DOC18-327885-35

Sutton Forest Quarry Project, Hume Highway, Sutton Forest (SSD 6334)

Attachment A

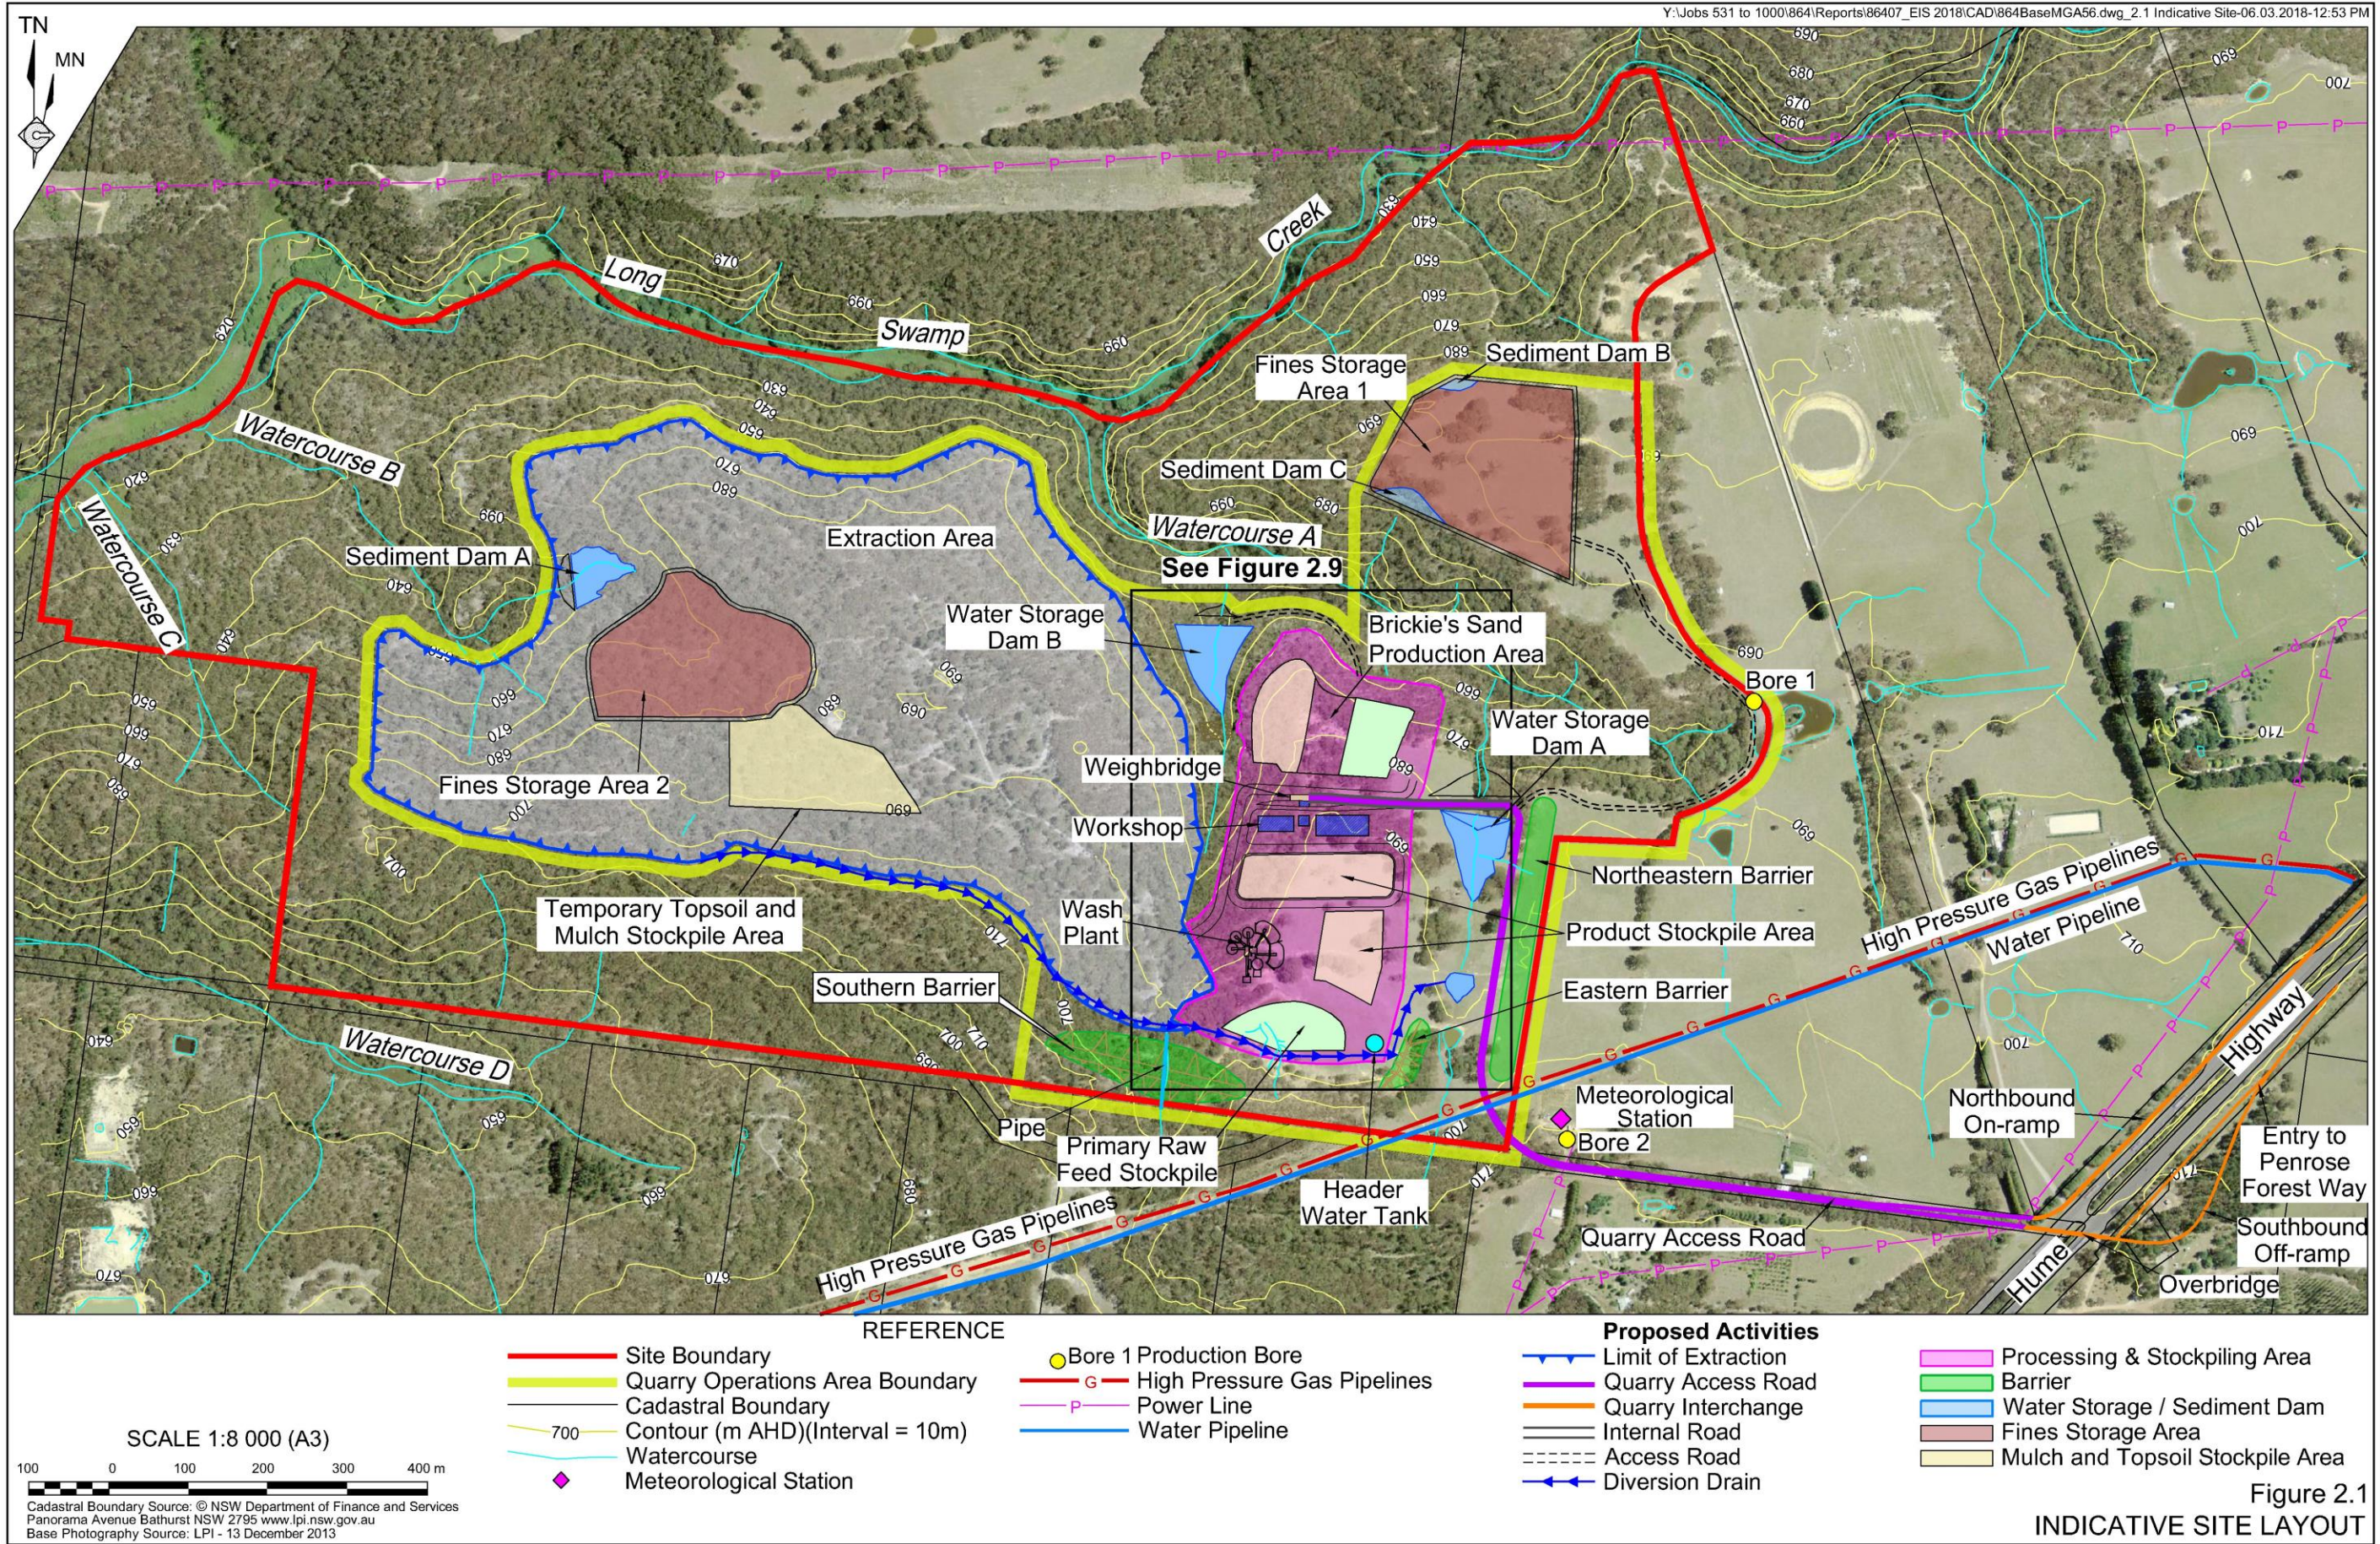
25. Figure 2.1 indicates that the "Fines storage area 1" appears to be located on top of a ridge. Section 2.7.3 states that this area will store up to approximately 350,000m³ of fines up to 8m high. Given the contours provided in Figure 2.1, this location may be more exposed to prevailing winds which may increase dust generation from the stockpile. This must be taken into consideration when developing suitable dust mitigation measures for the site should the development consent be granted.
